Harnett County
108 EAST FRONT STREET
LILLINGTON, NC 27546
Phone:
Fax:

SUBJECT: SFD1906-0026
SINGLE FAMILY DWELLING

Here are the results of all Inspections located at **5675 CHRISTIAN LIGHT RD:**

S1
FOUNDATION PLAN
1/4"=1'-0"

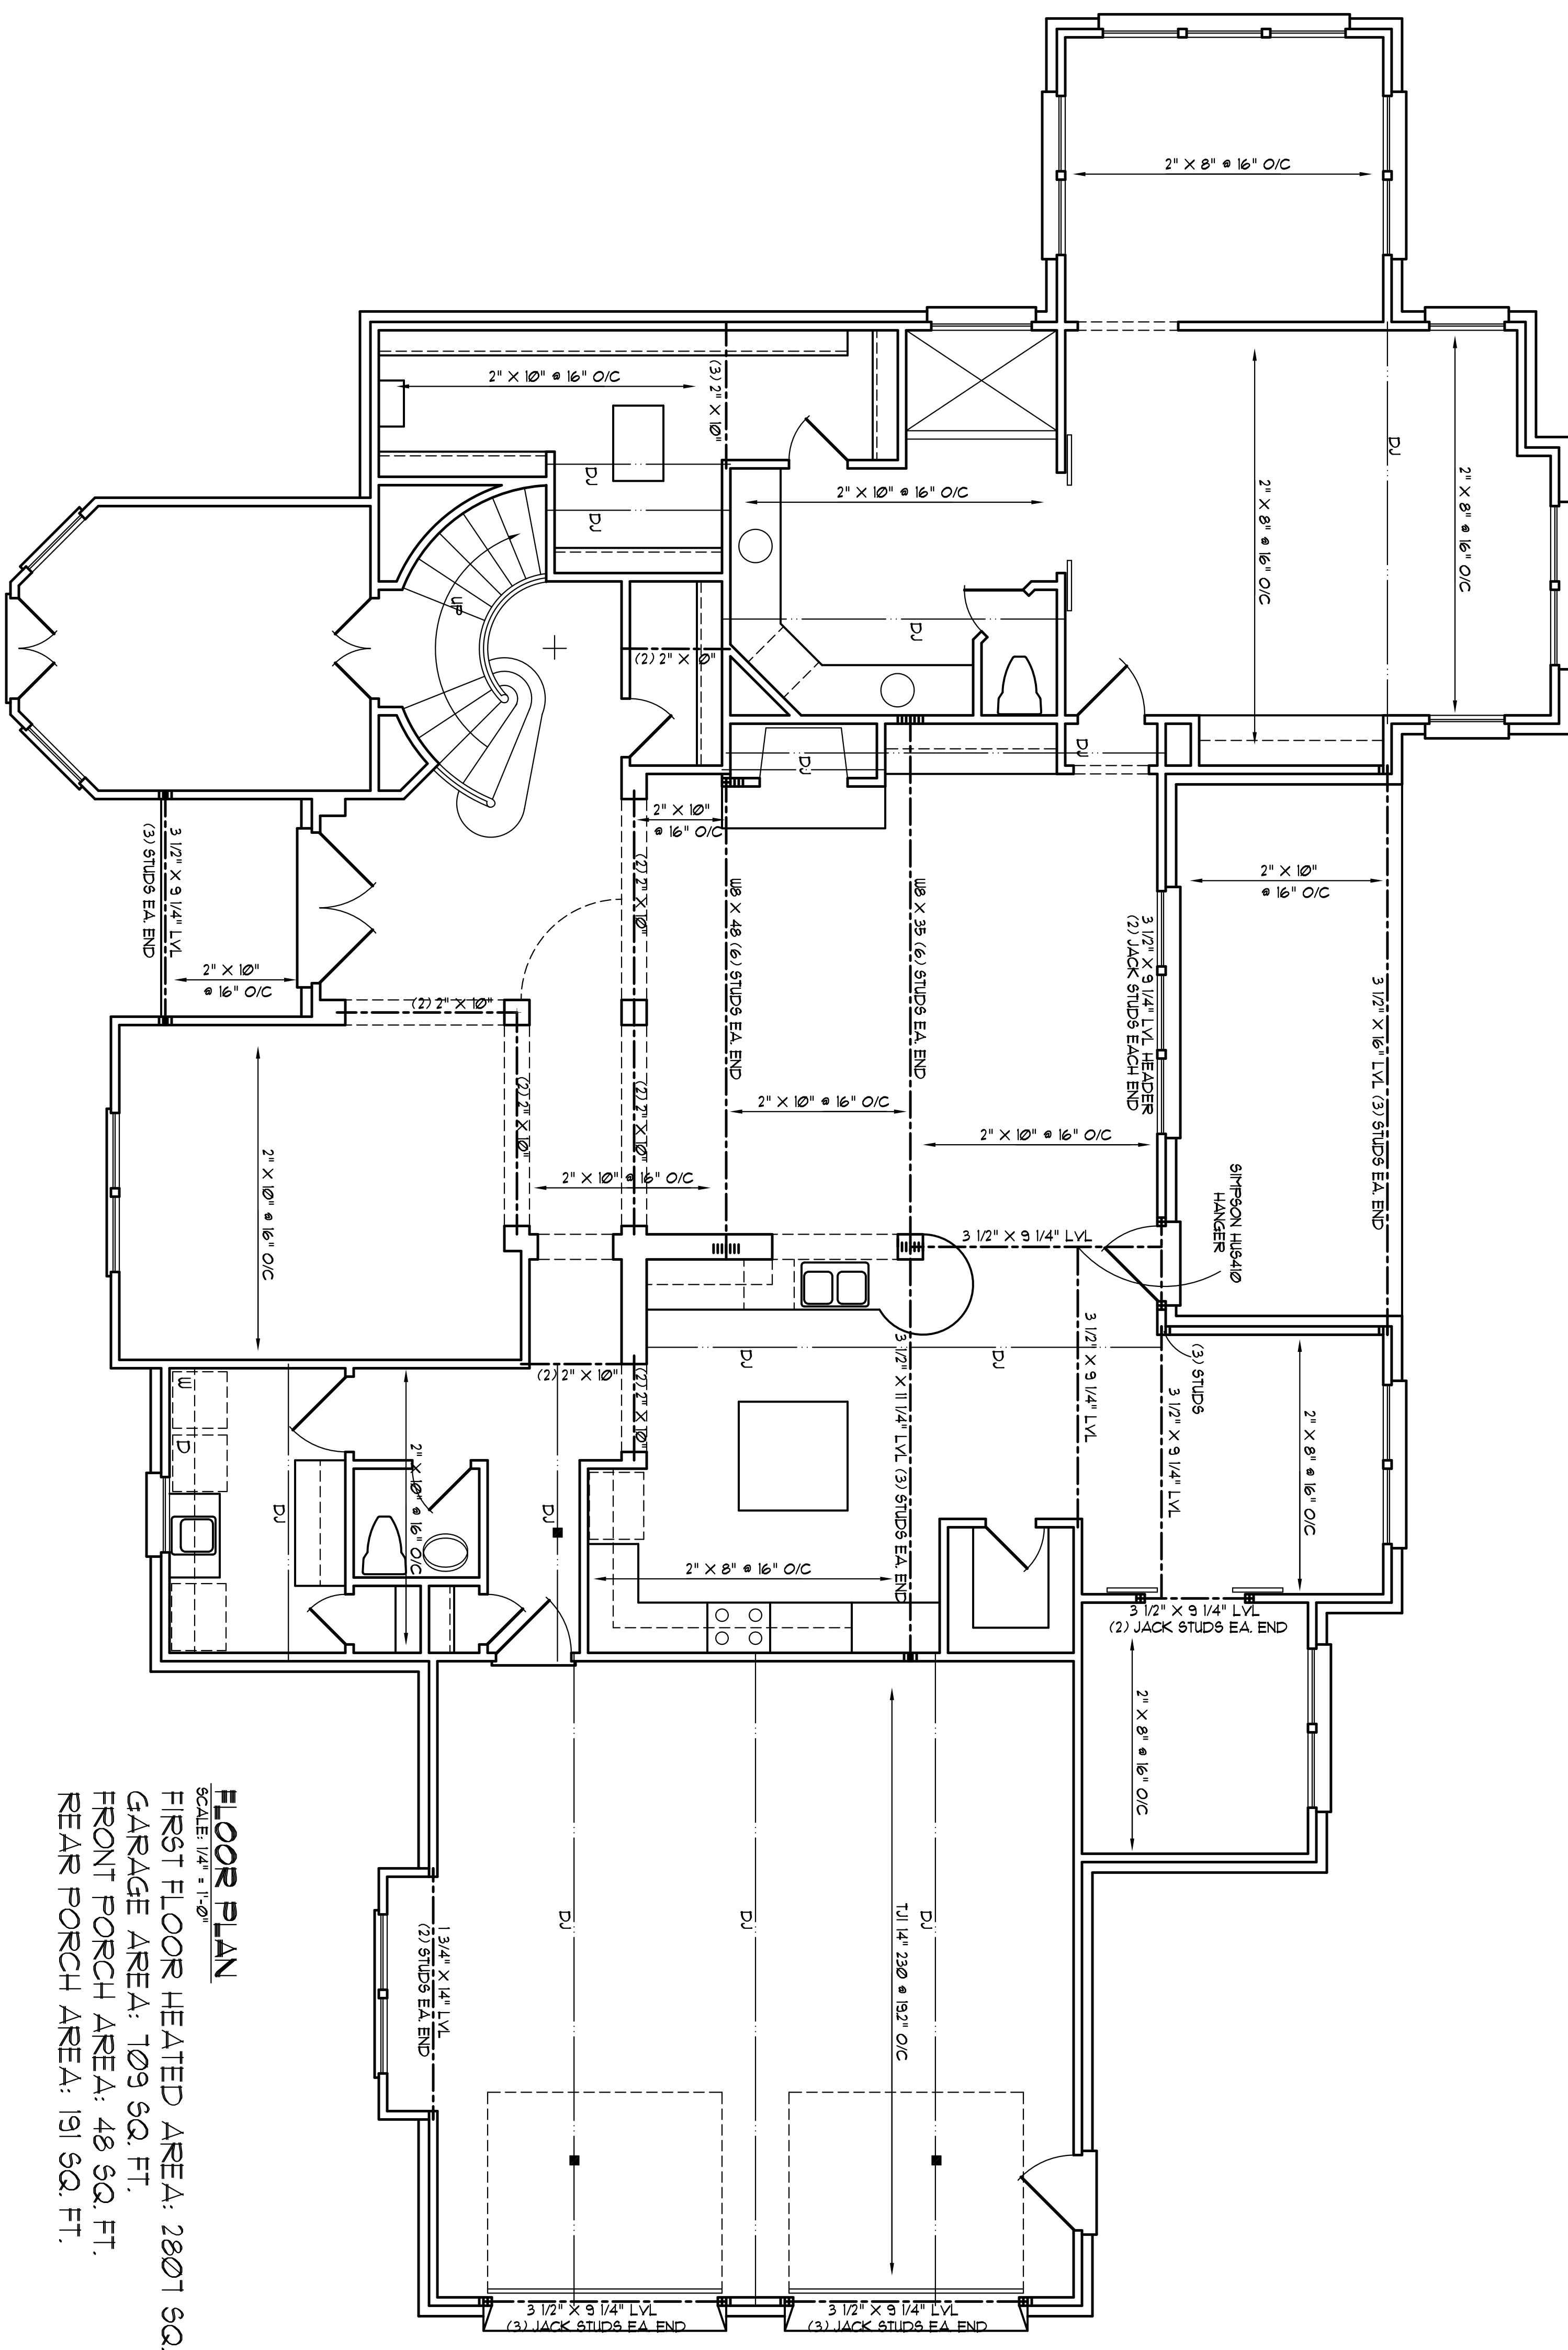
Inspection Type: FOUNDATION
Scheduled Date/Time: 8/26/2019
Completed Date/Time: 8/26/2019
Inspector: Slade Burton Lawson III
Result: DISAPPROVED
Remarks:
Notes: All piers shall be located on center 3rd of footing. Either move pier on get engineer repair letter to extend footing so pier is located in center 3rd.
